**Consultation Response from KC,
Strategic Housing**

2025/92178 Cockley Hill Lane, Kirkheaton, Huddersfield, HD5 0HH

Variation of condition 1 (plans and specifications) on previous permission 2021/91507 for reserved matters pursuant to outline permission 2014/91831 for erection of 54 dwellings, formation of access public space and associated infrastructure

Responding Ref: SH/25/92178

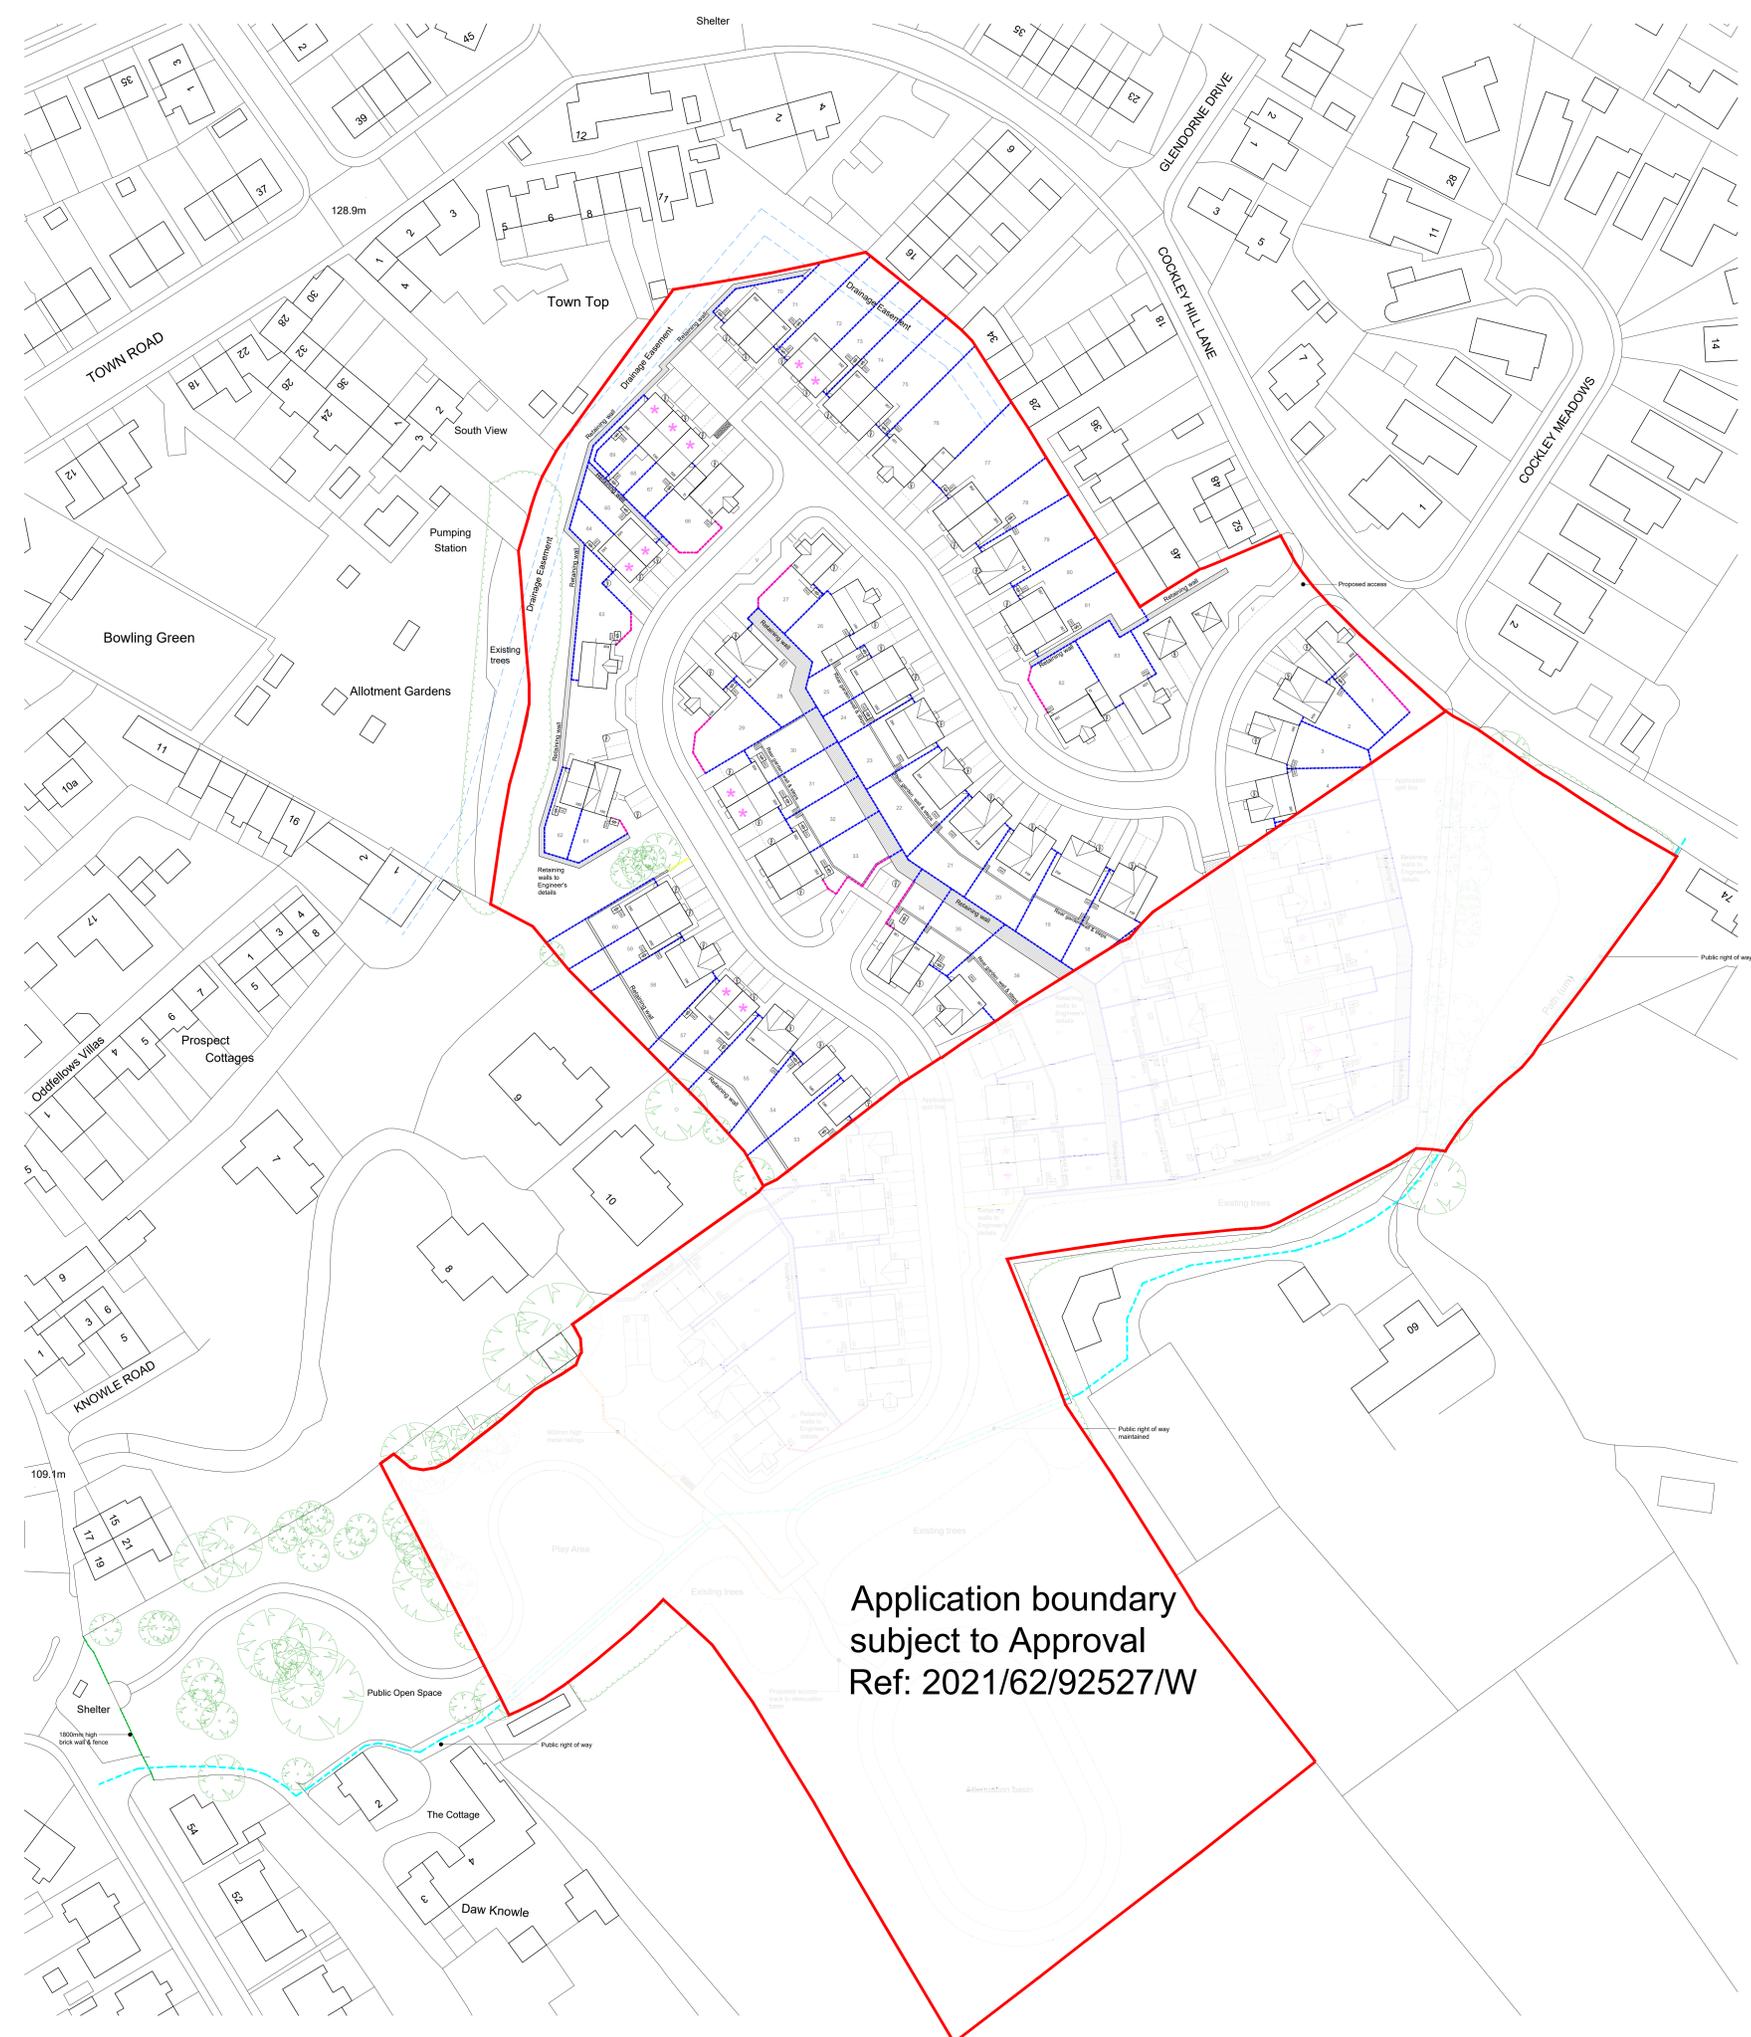
Strategic Housing request that the housing mix is amended to comply with the Housing Mix table for Huddersfield South set out above and in the SPD. If the applicant is unable to provide a compliant mix, evidence-based justification must be provided.

The proposed layout shows that the affordable homes are distributed evenly throughout the development and therefore, Strategic Housing does support the current proposal.
